Stormwater Detention and Infiltration Design Data Sheet

Facility Location & Jurisdiction: Cloverleaf Suddivision Filing 2 / El Paso County

POND 4- PLAN

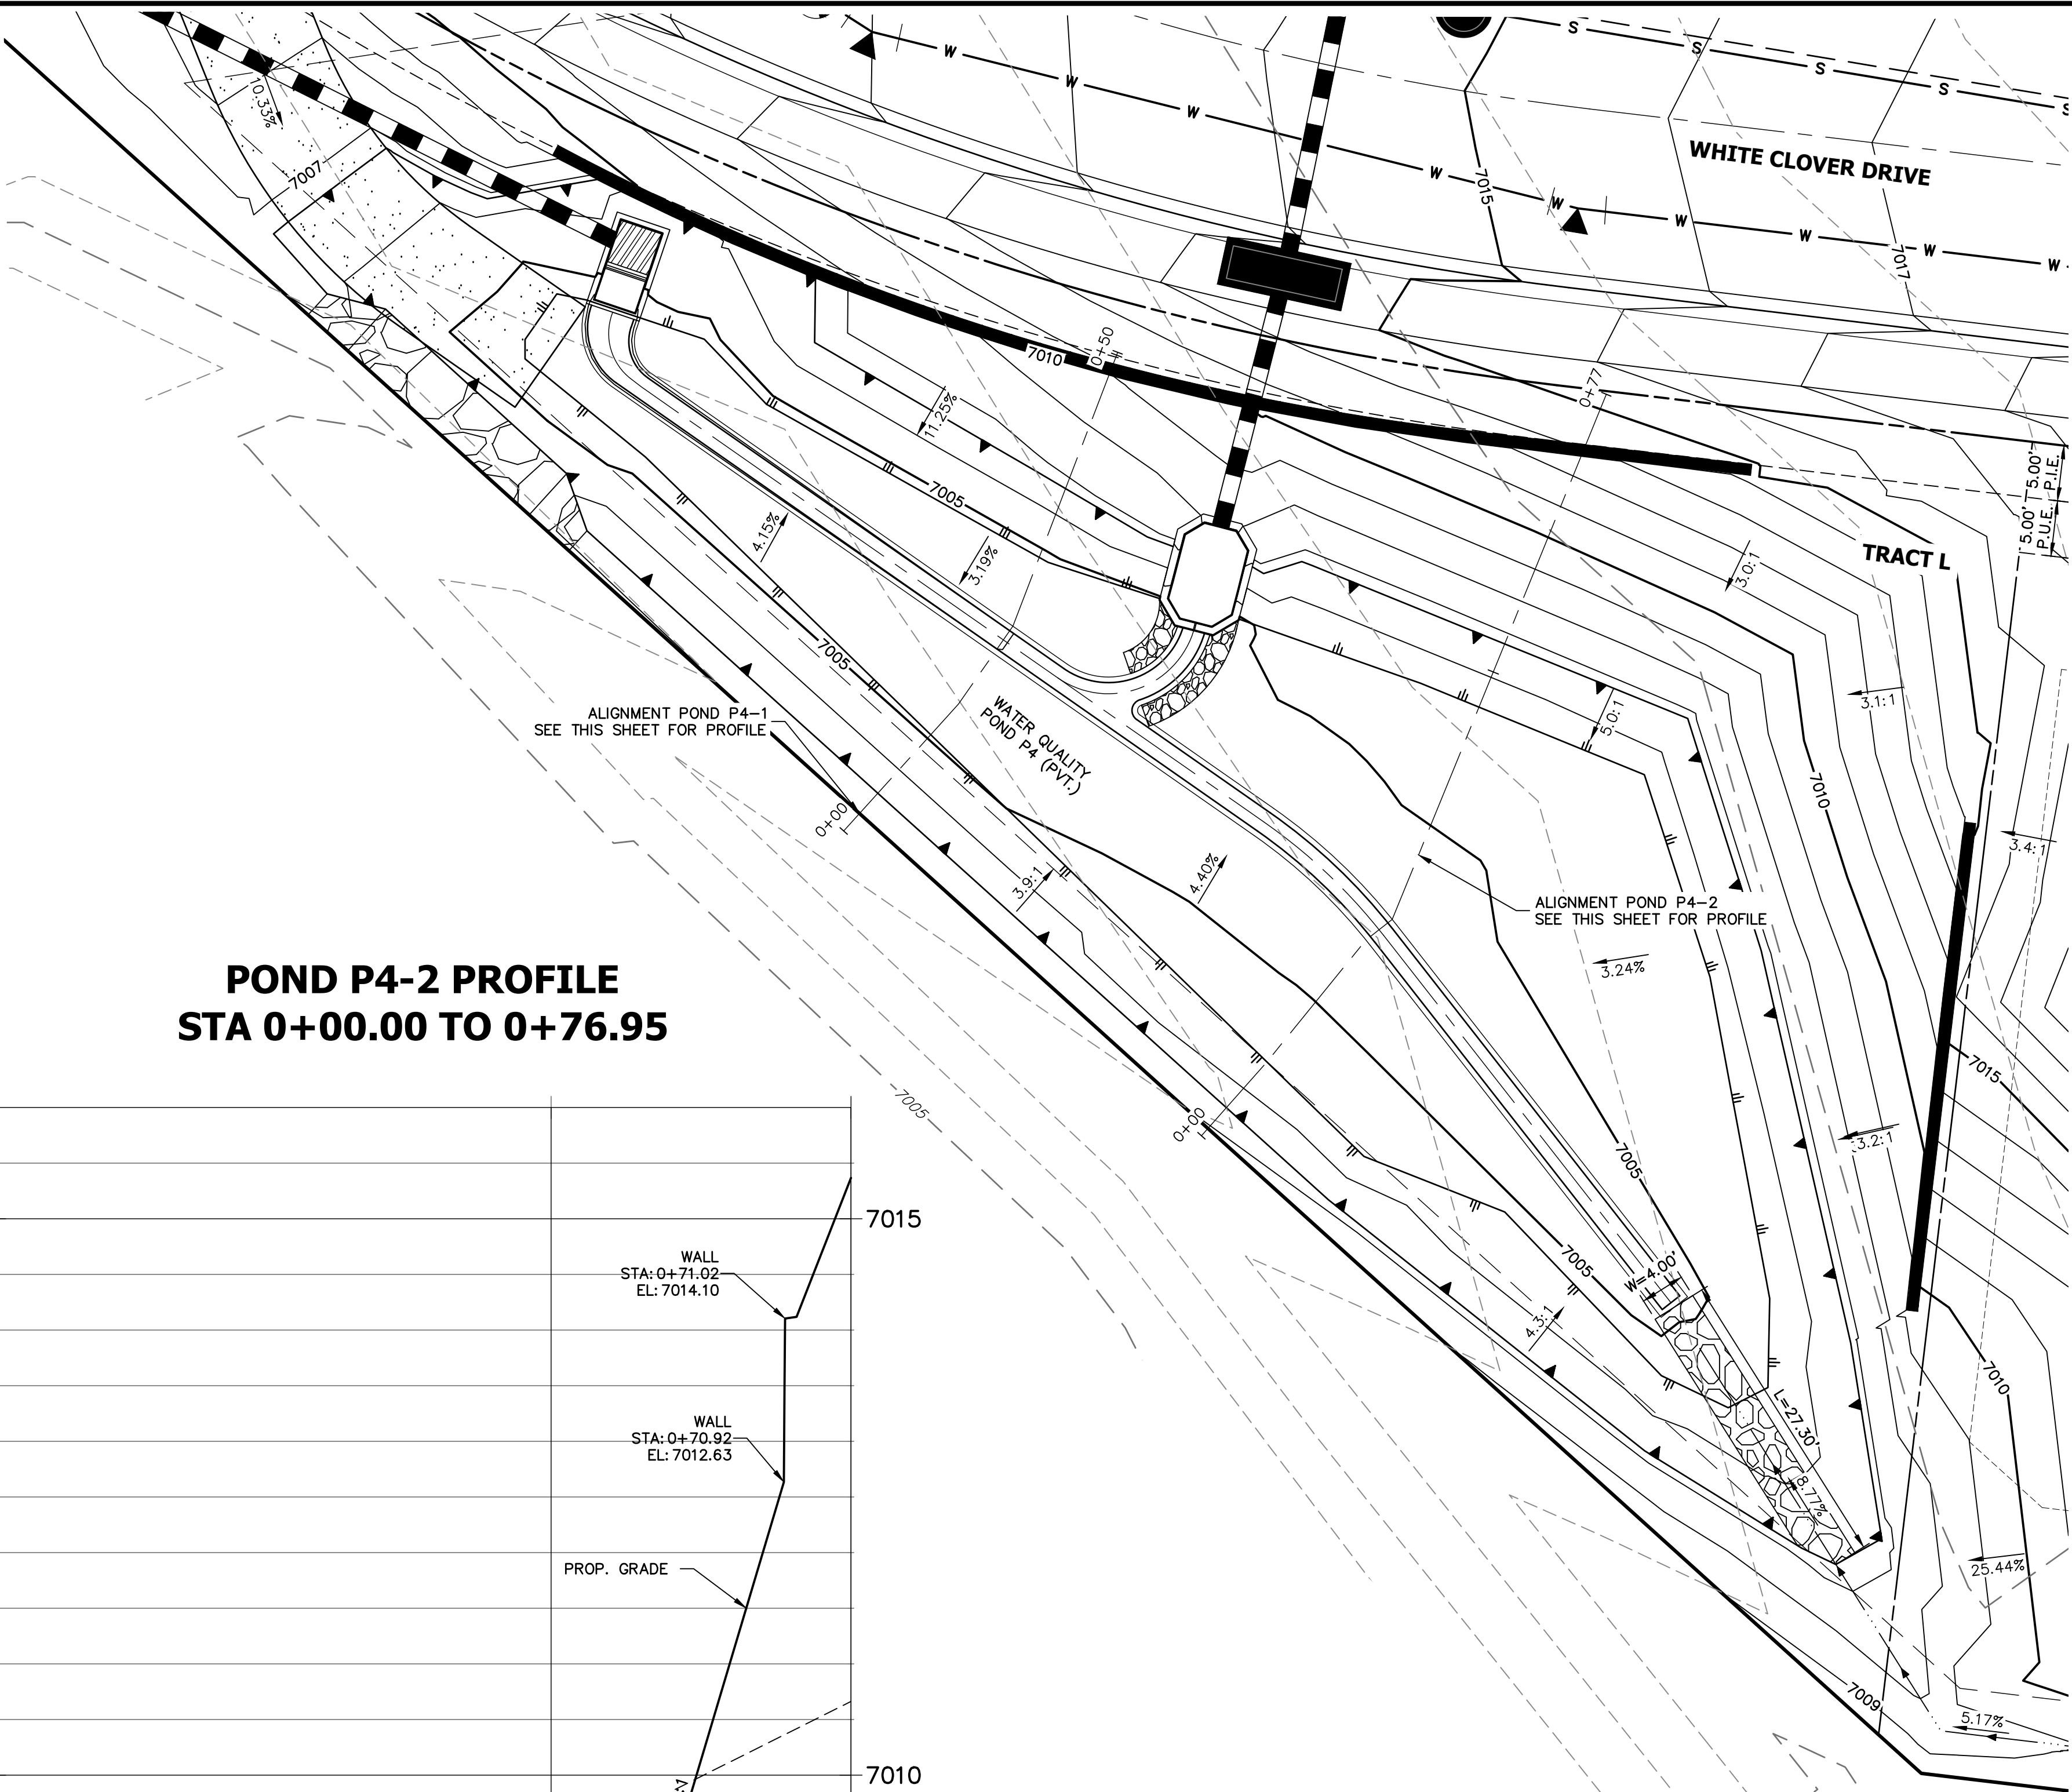
Please also complete one of these forms for Pond 4 as well even though it is not FSD and just for water quality. We still need to show the state that it is not holding water longer than is allowable. SDI forms are NOT required for sand filter basins.

JR - Addressed, Pond 4 added.
